Your Ref: TR010043  
Date: 28 November 2019

**Great Yarmouth Third River Crossing (GY3RC) ('the Scheme') – TR010043**  
**Application for Development Consent Order ('the Application')**  
**Norfolk County Council ('the Applicant')**  
**Applicant's intention to submit a request for proposed changes to the Scheme**

DRAWING NUMBER
GYTRC-NCC-HGN-XX-DR-CB-1010

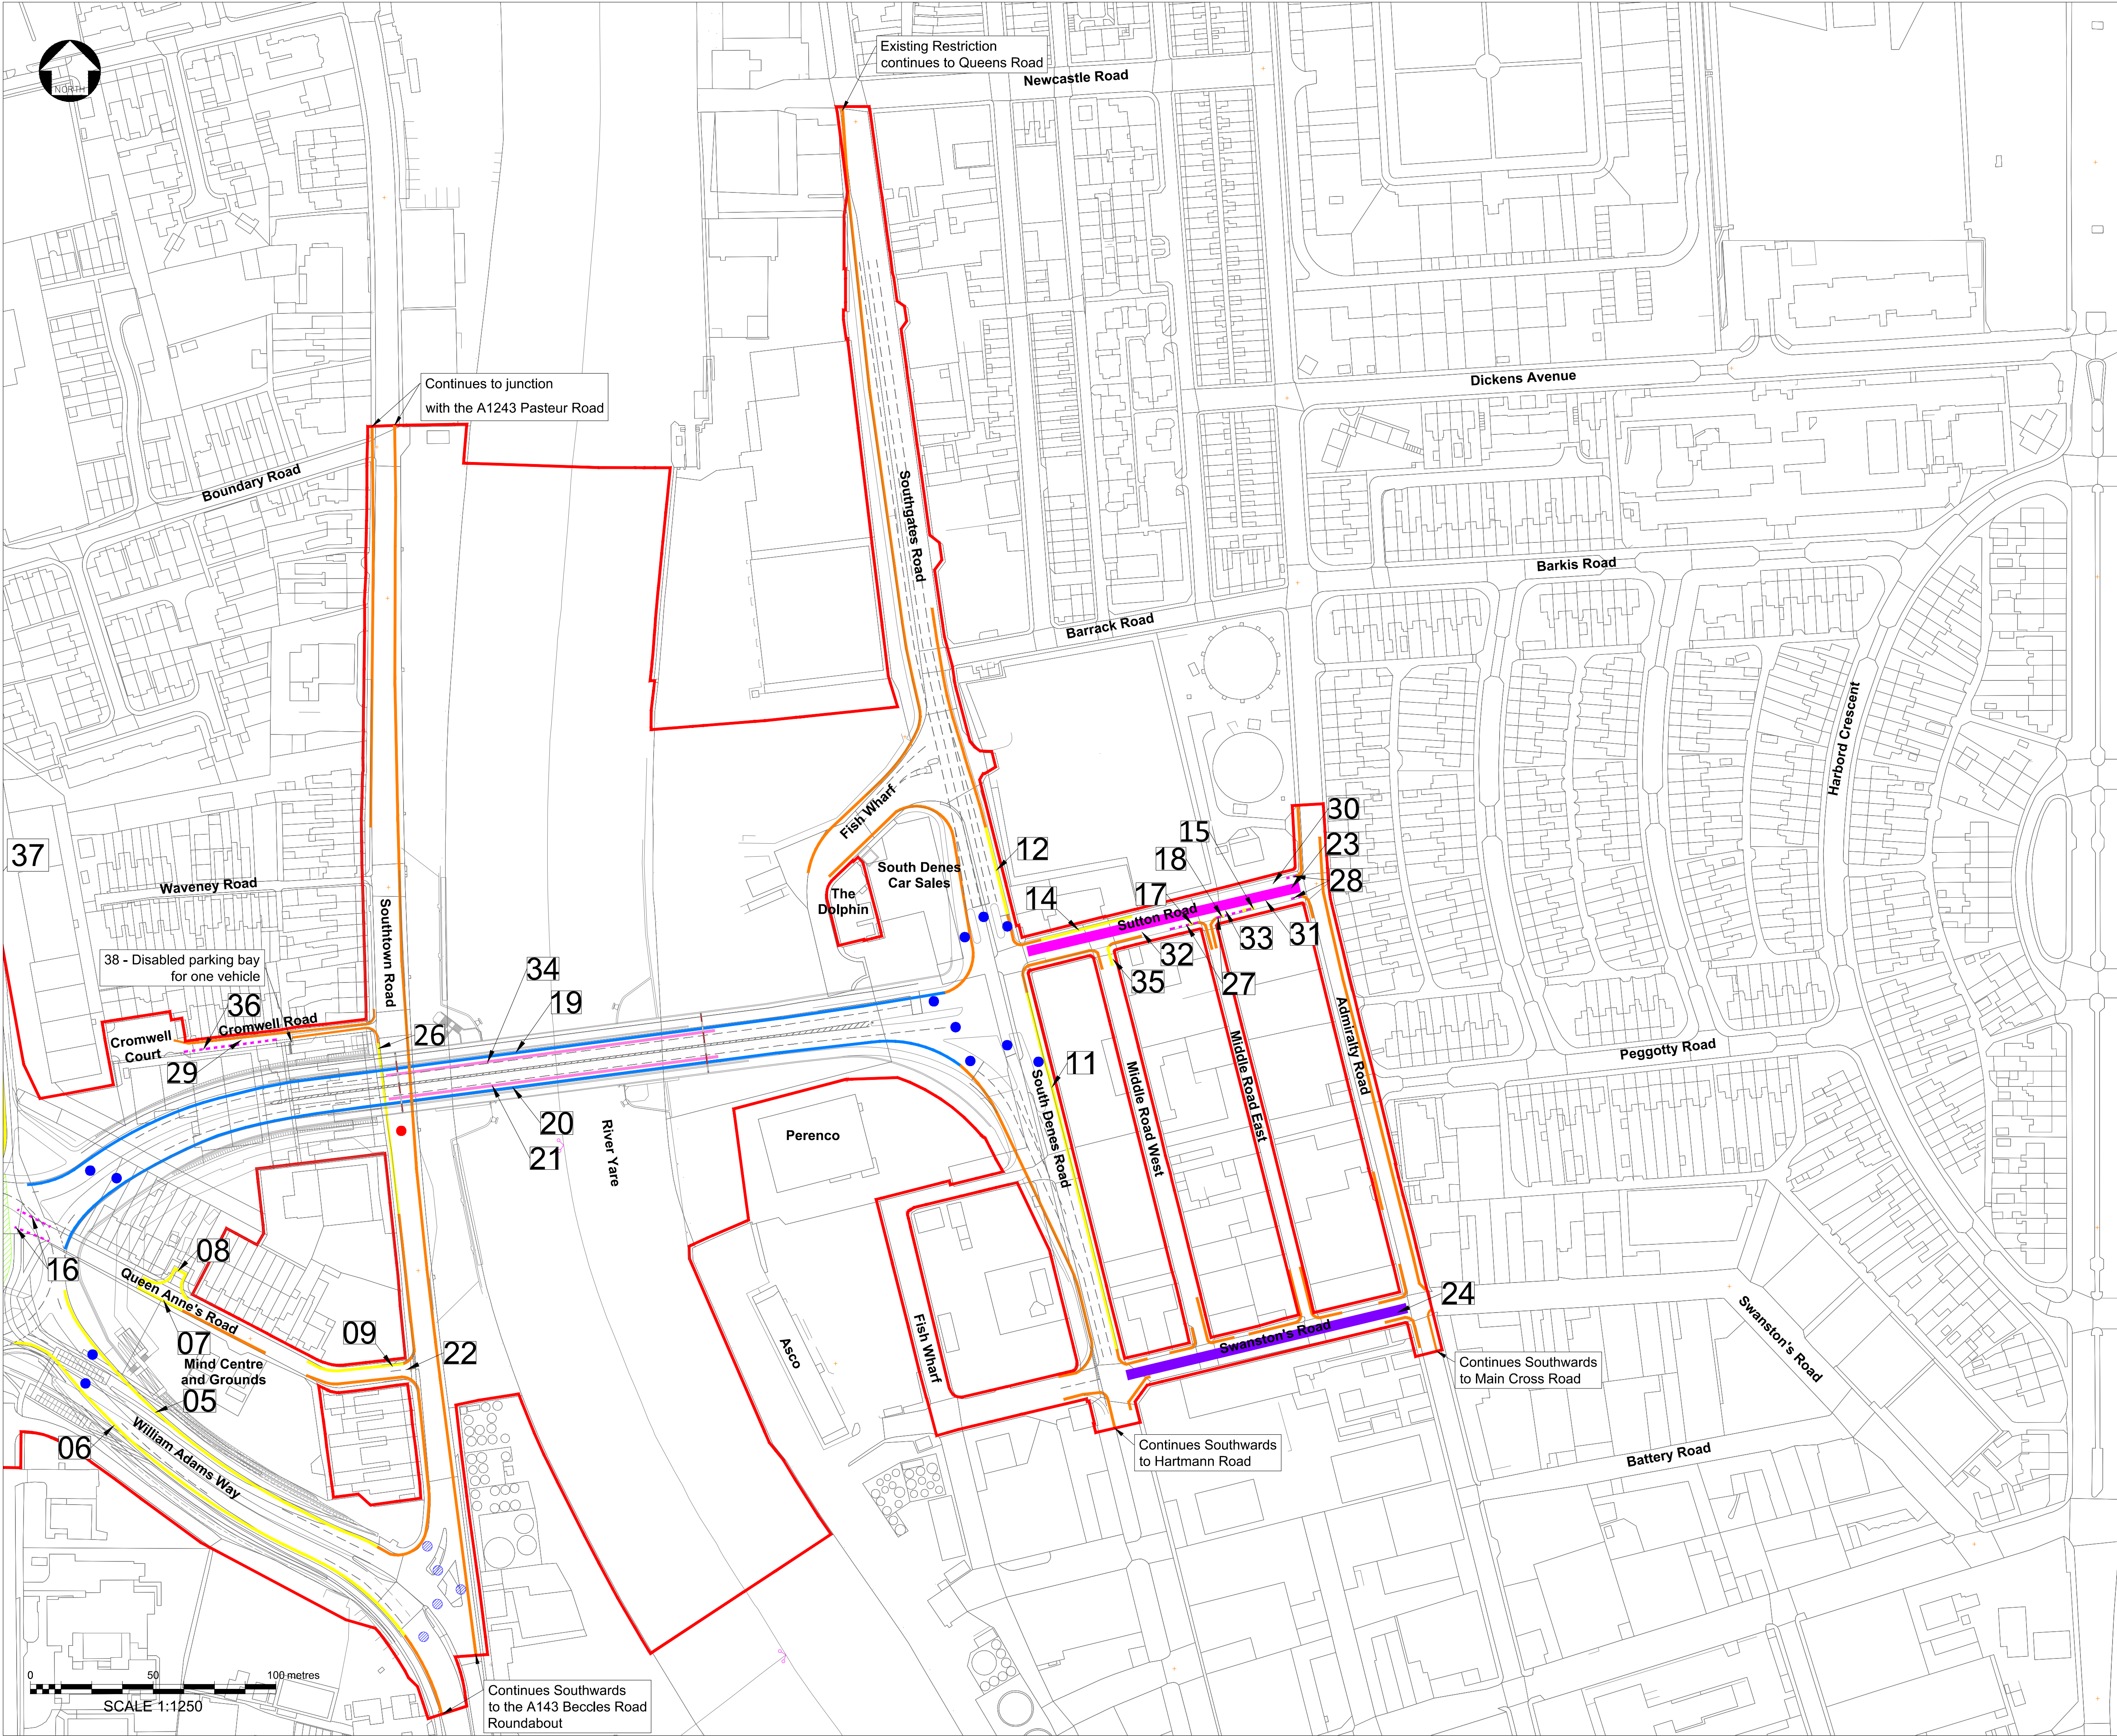
- ***Removal of the 'no waiting at any time' restriction (identified as Traffic Regulation Measure Reference Numbers 10 on Traffic Regulation Measures Plan Sheet 2 of 2 (Document Reference 2.3, Planning Inspectorate Reference APP-008)).***

- ***Removal of the restriction identified as Traffic Regulation Measure Reference Numbers 13 on Traffic Regulation Measures Plan Sheet 2 of 2 (Document Reference 2.3, Planning Inspectorate Reference APP-008)).***

- ***Reduction by 20m at its western end of limited waiting restriction (1 Hour Parking - 2 Hours No Return) between 8am & 6pm Monday to Saturday on the north side of Queen Anne's Road (identified as Traffic Regulation Measure Reference Number 03 on Traffic Regulation Measures Plan Sheet 2 of 2 (Document Reference 2.3, Planning Inspectorate Reference APP-008)).***

- ***The provision of a 6.6m long disabled parking bay (available at all times) to be located at the western end of the proposed parking bays which are proposed to be provided along the southern side of Cromwell Road.***
